Our ref: HA/2019/121089/01-L01
Your ref: A/146/18/PL
Date: 26 February 2019

CONSTRUCTION OF NEW SEMI-DETACHED DWELLING EXTENDING EXISTING TERRACE OF COTTAGES.

LAND ADJACENT TO 4 GLADSTONE COTTAGES WATER LANE ANGMERING BN16 4EL

Based on the information provided within Ambiantal Consultants Flood Risk Assessment (FRA) we **object** to the proposal as the current FRA is inadequate for the following reasons:

Figure 2: Proposed compensatory flood storage areas, taking into account car parking areas

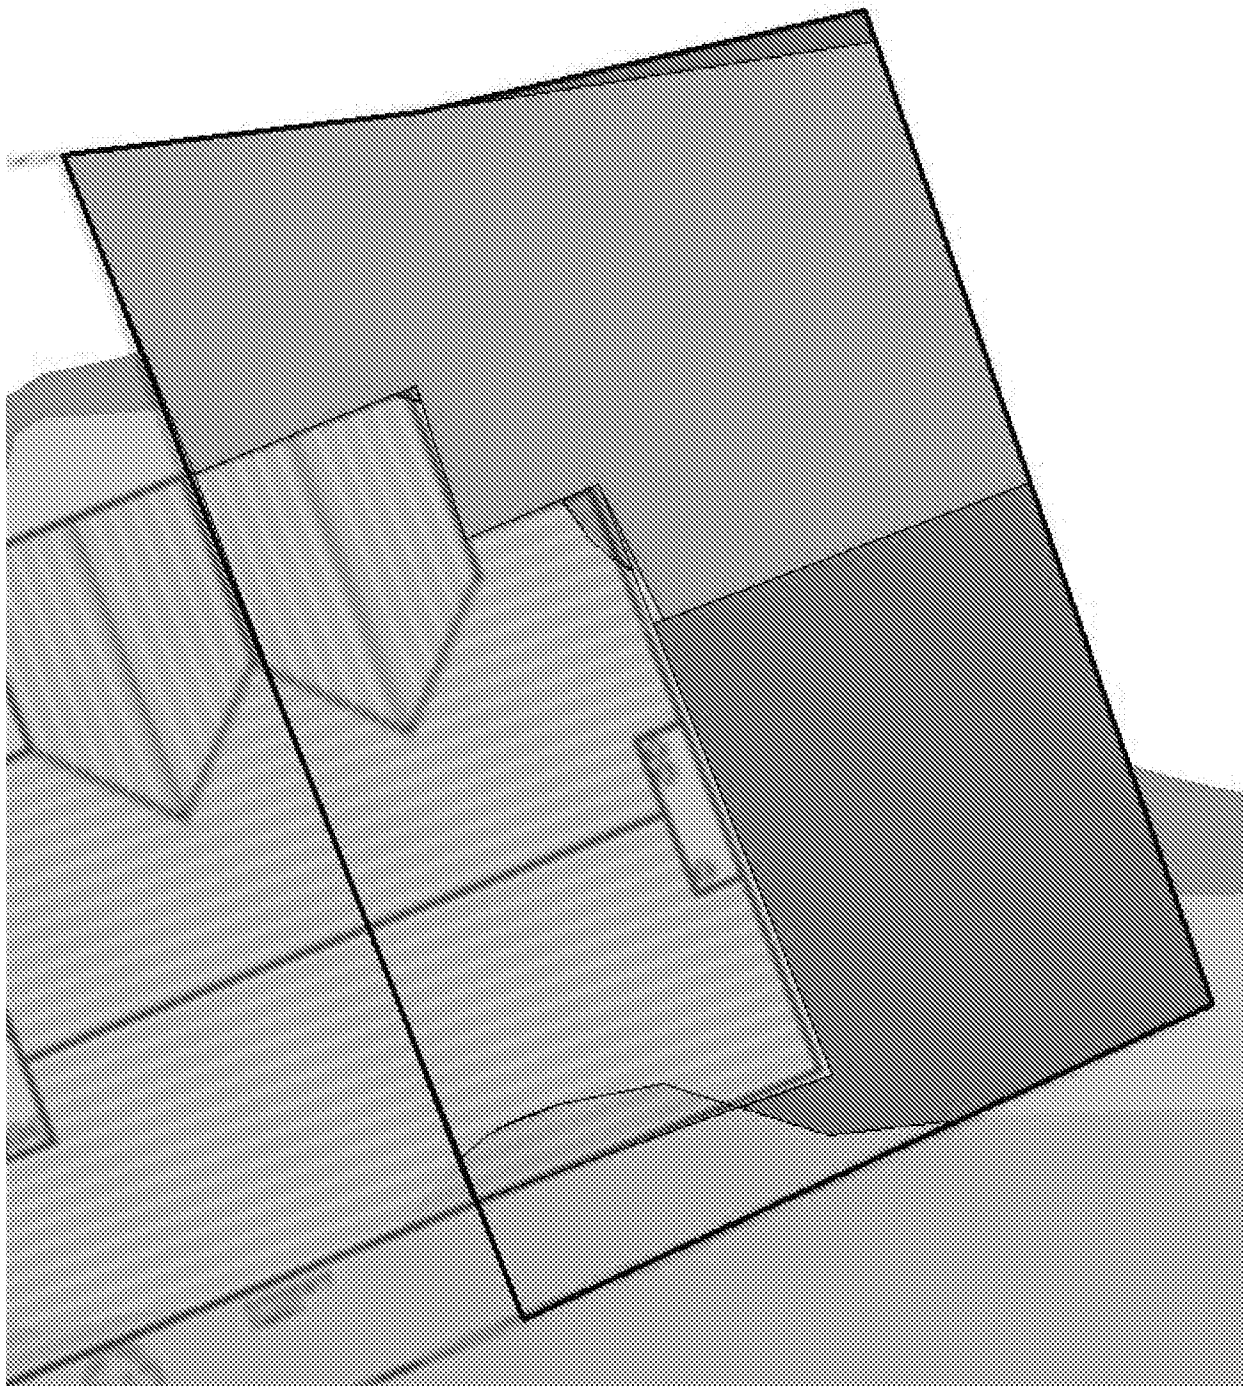
As flooding in terms of duration is often brief, and given the size, the benefits of the flood compensation area, are unlikely to be of a little benefit.
